Appeal No: ABP 321465

**REF: Case number ABP-321465-24**

I refer to your letter dated 30<sup>th</sup> June 2025 in respect of submission received from the DAA and I comment are as follows.

I refer to your letter dated 30<sup>th</sup> June 2025 in respect of submission received from the Department of Housing, Local Government and Heritage and I comment as follows.

DRAINAGE LAYOUT

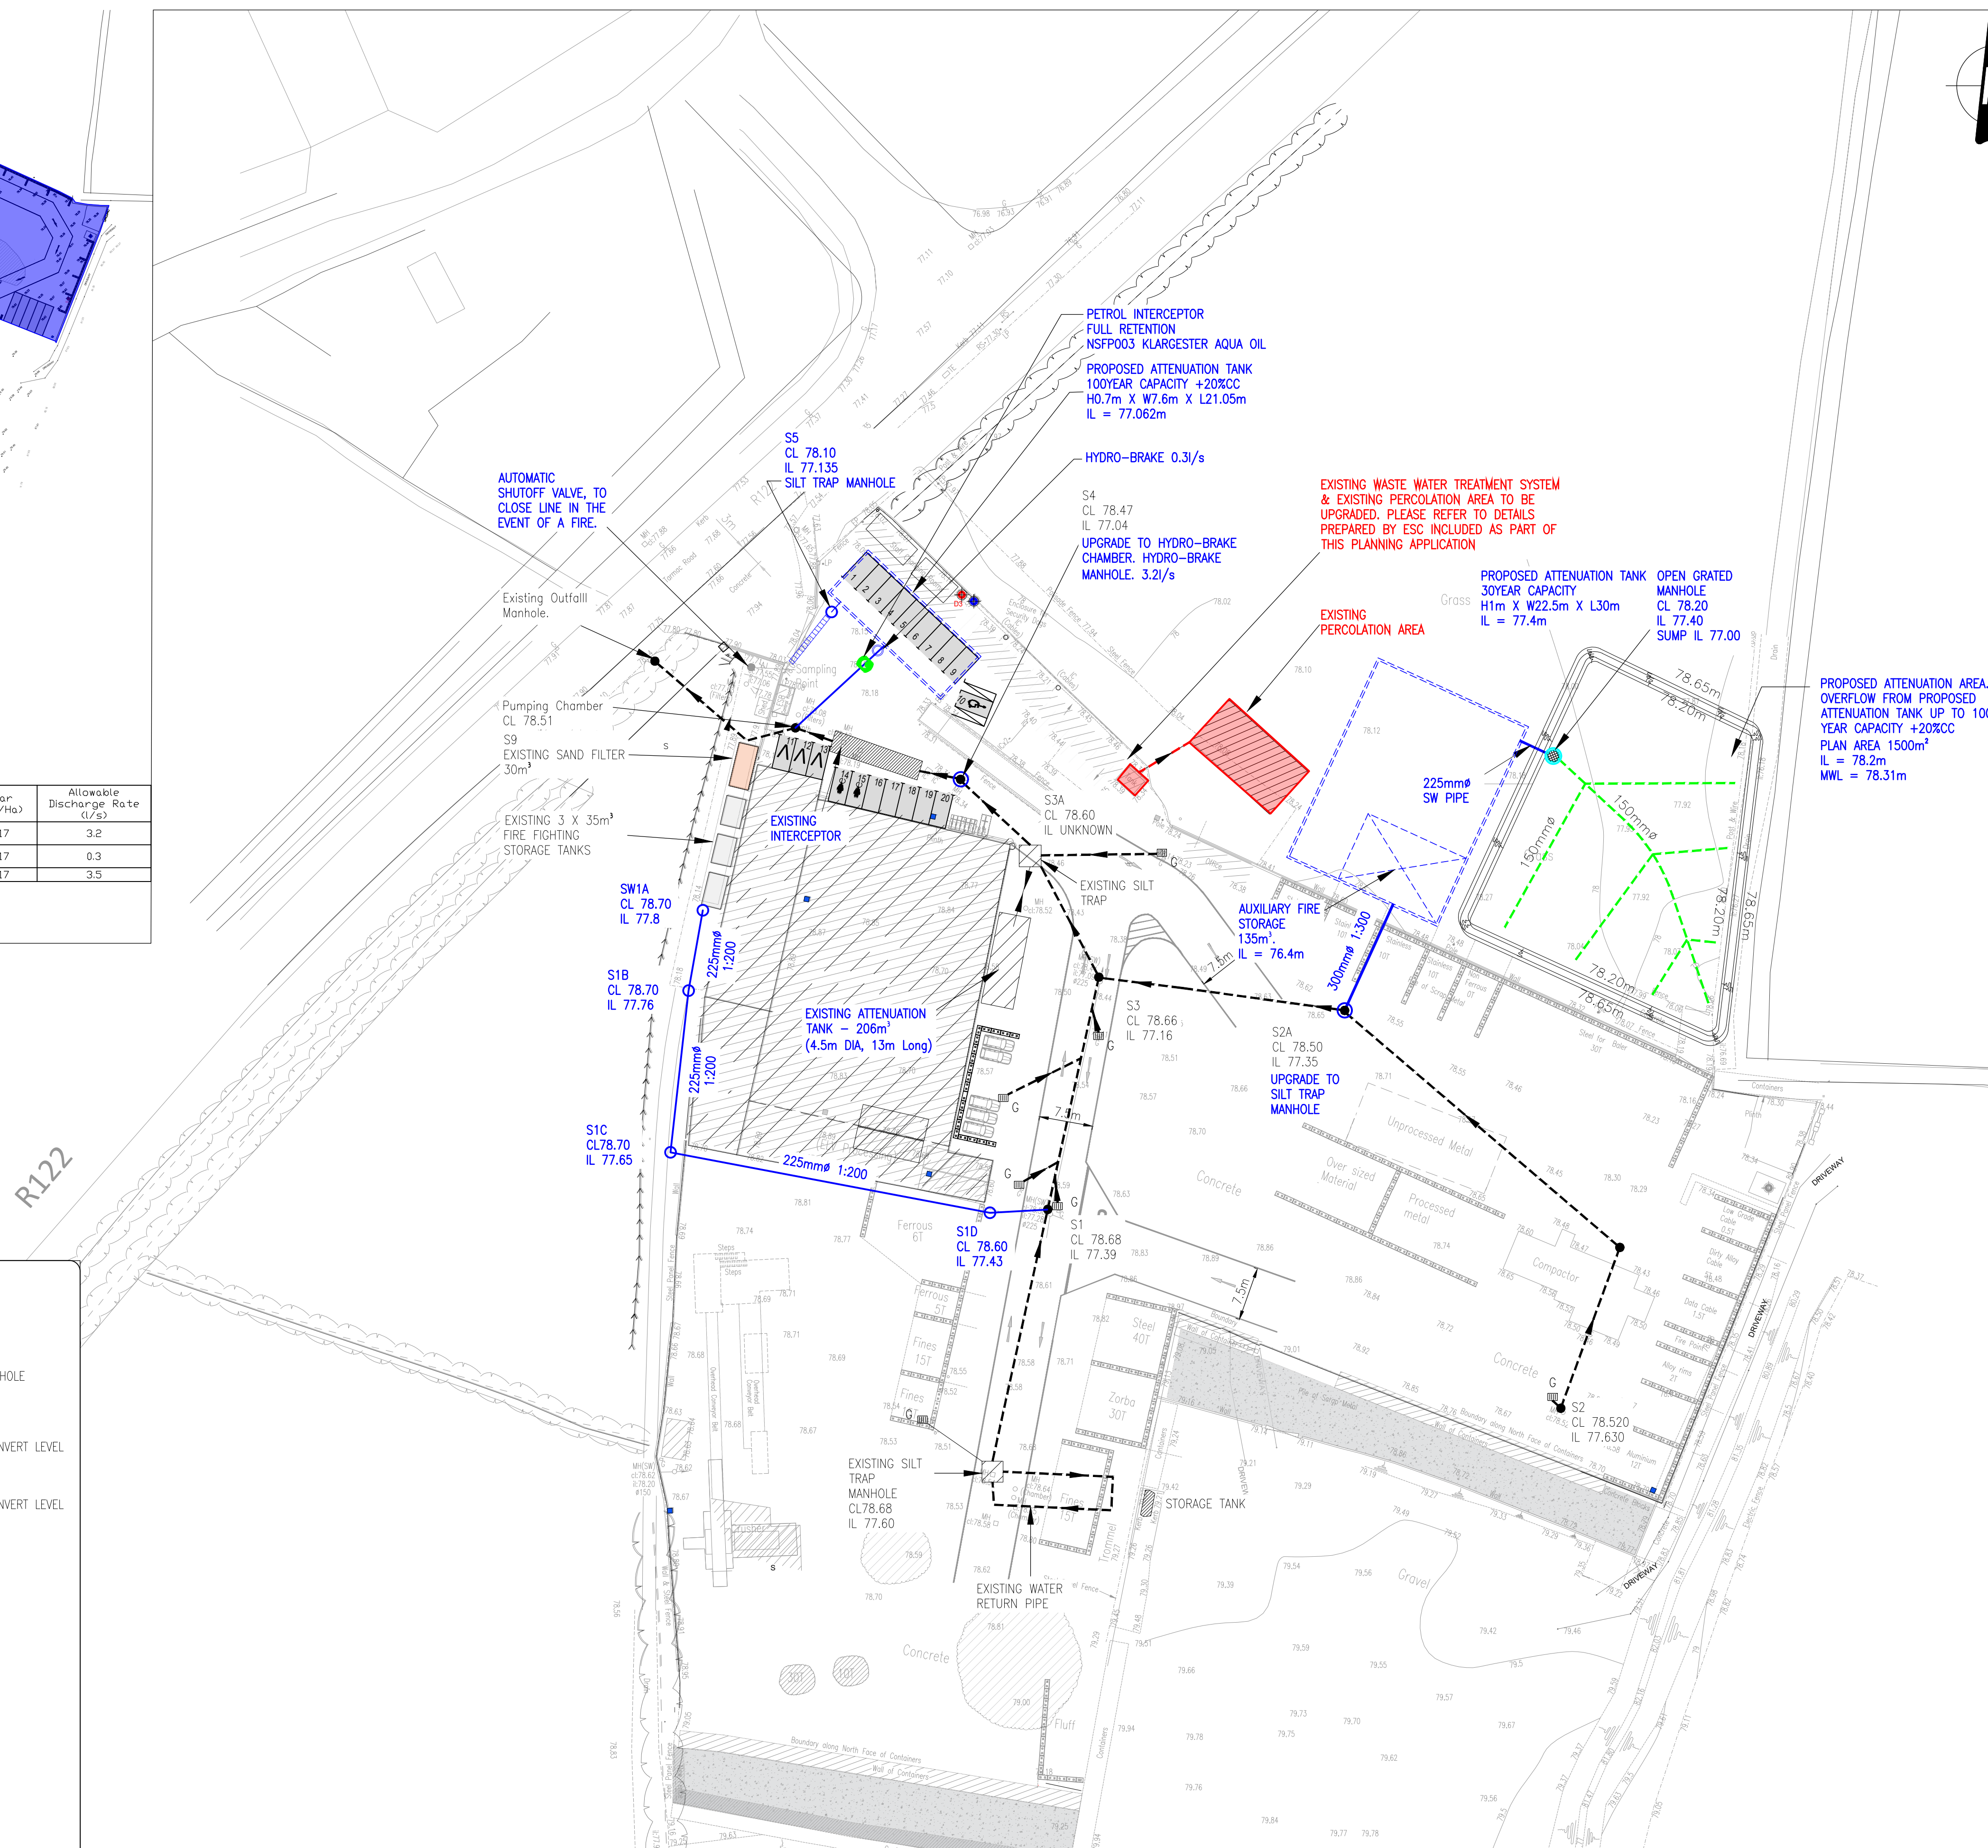
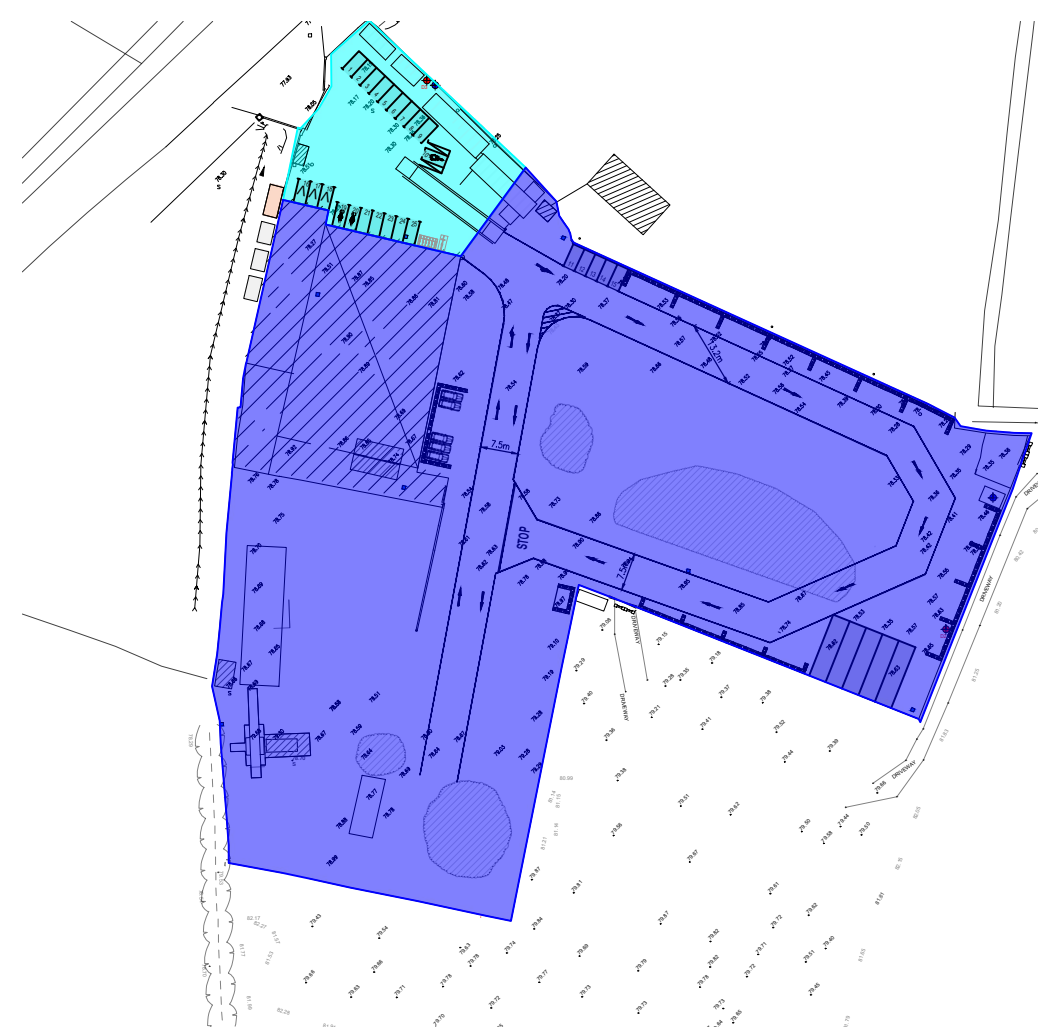
The DAA have noted, why sustainable urban drainage systems (SUDS) are essential for managing surface water and promoting environmental resilience. The SUDS system promoted by the applicants is not suitable and not fit for purpose at such a development, that not only causes problems for the airport in relation to water bodies put primarily is designed for clean surface water, i.e. water also that is totally uncontaminated and causes no risk whatsoever to the water body itself.

In the Saint Margaret's scenario, the surface water from the localised sheds shall be retained on site for washing down water. It was also recorded in previous documentation by the applicants that dusting down and washing down of the rooftops would be necessary because of particles of contaminants leaving the site and or being airborne from the activities being carried out from shredding of bailing stock, piling, sorting of all kinds of scrap, car parts, engine parts, etc, being processed in an open area at the rear of the premises.

It has also been noted that any water from quarantine/stockpile or wash down from within the yard area will enter the surface water system, which is not fit for purpose, within the drainage system and exit into the open localised water drainage system. The substantial risks are the pollutants being released from the activities within the yard, i.e. oils, hydraulic oil, brake fluid, gear oil, antifreeze, paint, battery fluid, lead particles, metal particles, and their combinations. There

is also the risk of fire water being released into the ground water system in the likelihood of a major incident, as has been previously documented.

The treatment of surface water and the submissions by the applicants over the course of numerous submissions to the local authorities, the Planning Board and the Waste Department of the local authority, lack any comprehensive plan to deal with surface water management. The applicants have not shown the competency to deal with this issue to meet the requirements for the local area including the concerns of the DAA and local government.

The proposal by the DAA for underground attenuation or rapid infiltration system was never proposed by the applicants and may not be sufficient based on the calculations submitted as NO allowance has been made for firewater, torrential rain and those factors that have announced themselves quite recently with climate change events.

There is a significant concern that any underground attenuation would need to be outside the proposed boundary of the site and would mainly carry and store contaminated water containing pollutants from the activities in the open yard processing area.
